# **REPORT on the IMPLICATIONS for EUROPEAN SITES**

## **Proposed Tees CCPP**

Planning Inspectorate Reference: EN010082

05 September 2018

H1.36 Their locations are shown in *Figure 7.4 (Air Quality, Sensitive Ecological Receptors)* which is reproduced below as *Figure H2.1*.

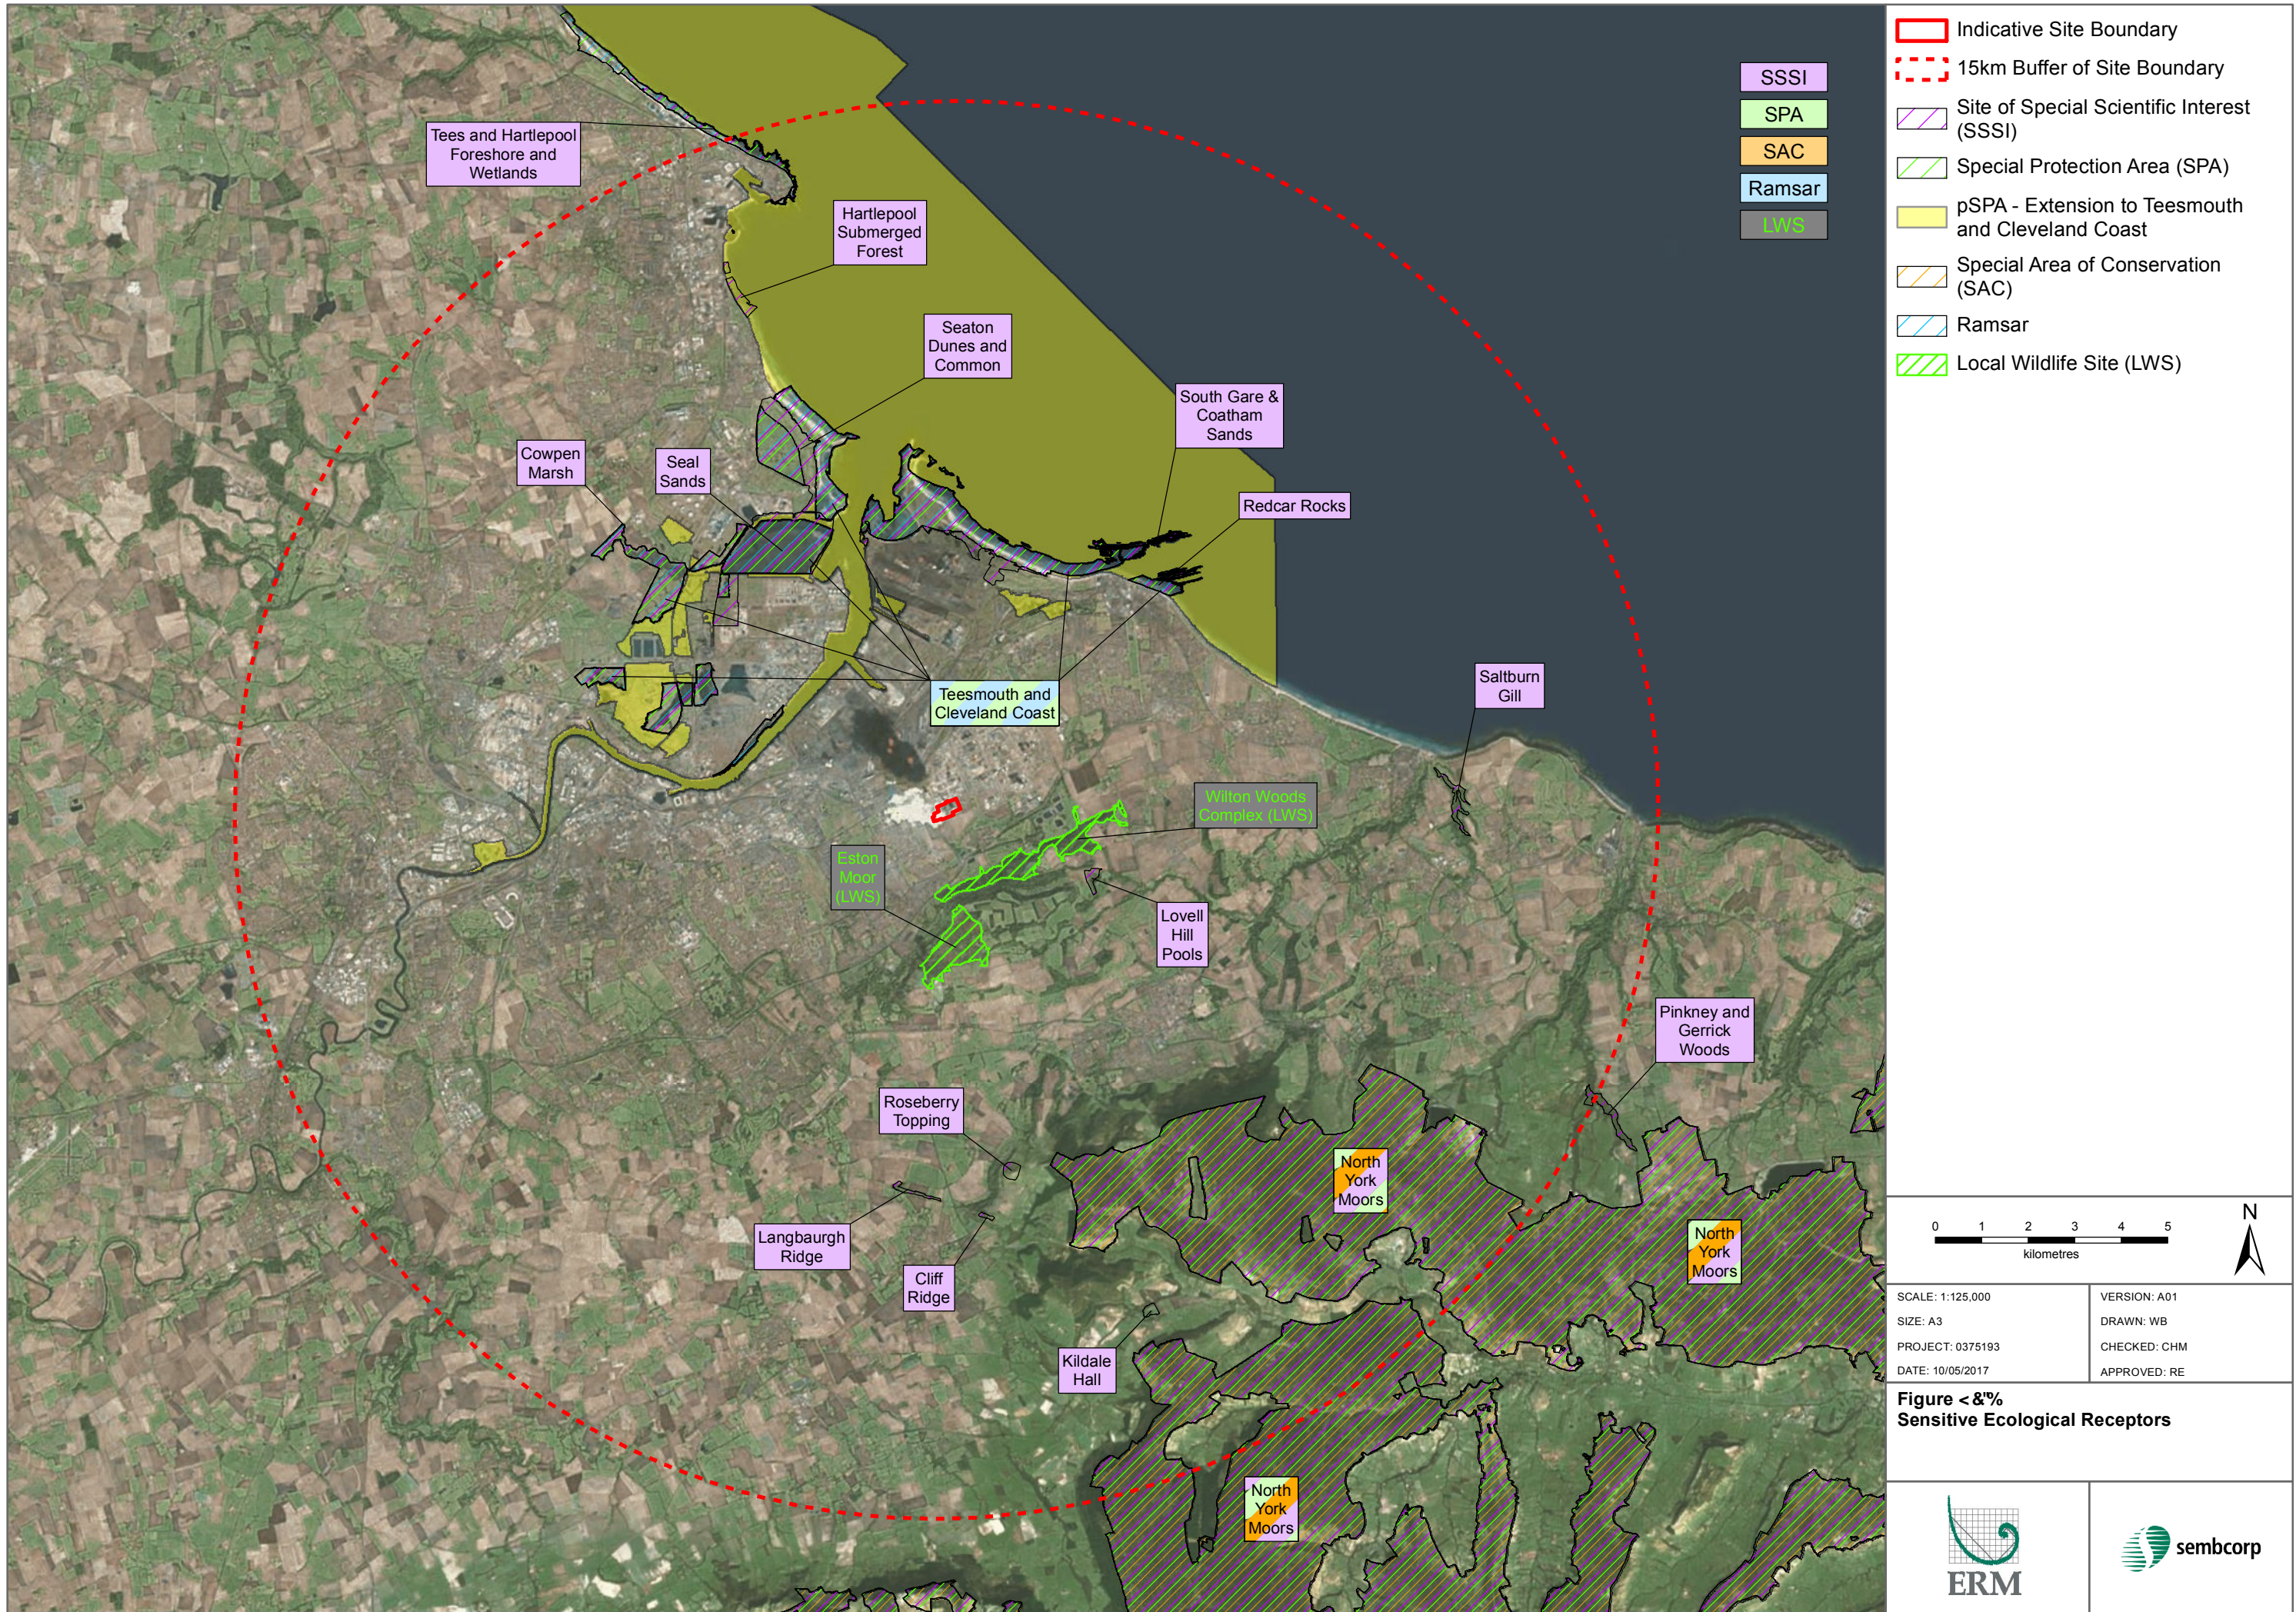
- 2.1.3 The locations of these European sites relative to the application site are illustrated on Figure H2.1 of the NSER [REP1-001].
- 2.1.4 NE confirmed in its relevant representation [RR-007] the European sites which it considered relevant to the application; all of which have been identified and considered by the Applicant in its NSER.

- 2.1.5 The NSER also refers<sup>6</sup> to a possible extension to the Teesmouth and Cleveland Coast SPA, which would include additional marine and terrestrial areas as part of the SPA and additional species as qualifying features [REP1-001]. The extent of the possible extension is illustrated on Figure H2.1 of the NSER [REP1-001]. The Applicant considers impacts to the possible SPA extension (including provision of a screening matrix) in the NSER [REP1-001]. The NSER [REP1-001] identifies common tern and pied avocet as proposed new qualifying features of the possible SPA extension and considers impacts to these species.

**Figure H3.1** *Additional Zones Reviewed for Potential (Large Combustion Project) Cumulative Schemes*

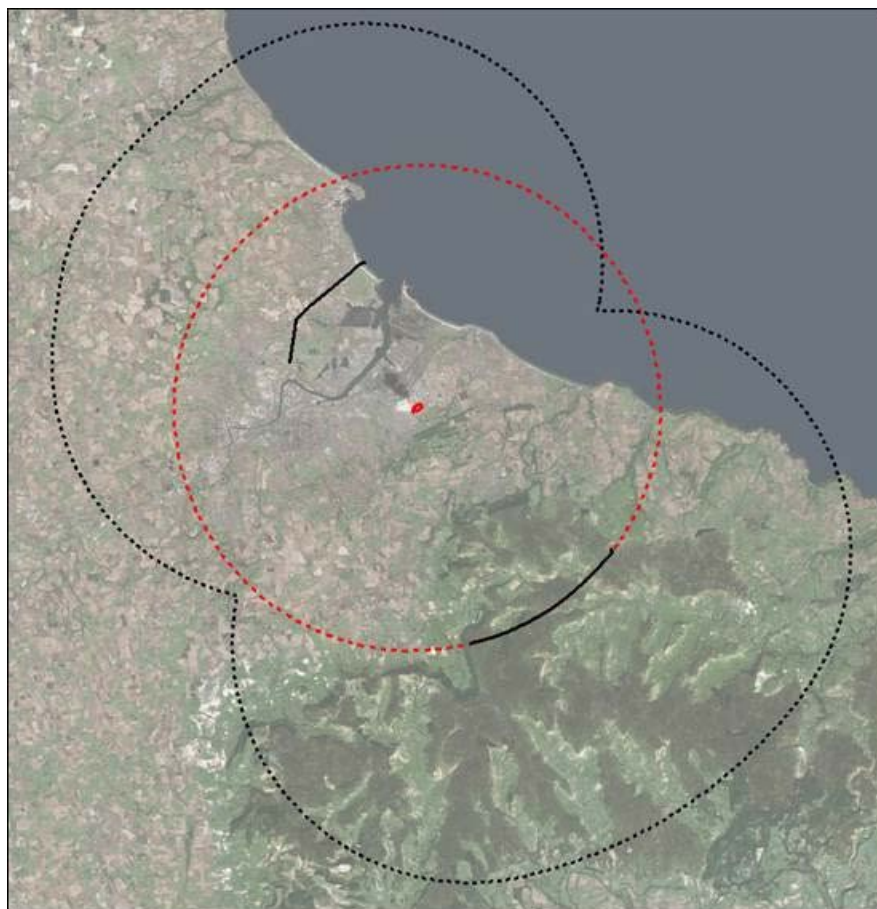
combustion projects' for consideration in the in-combination assessment. This additional search area is illustrated on Figure H3.1 of the NSER [REP1-001]. Paragraph H1.70 of the NSER [REP1-001] confirms that no further large combustion projects were identified within this additional search zone.
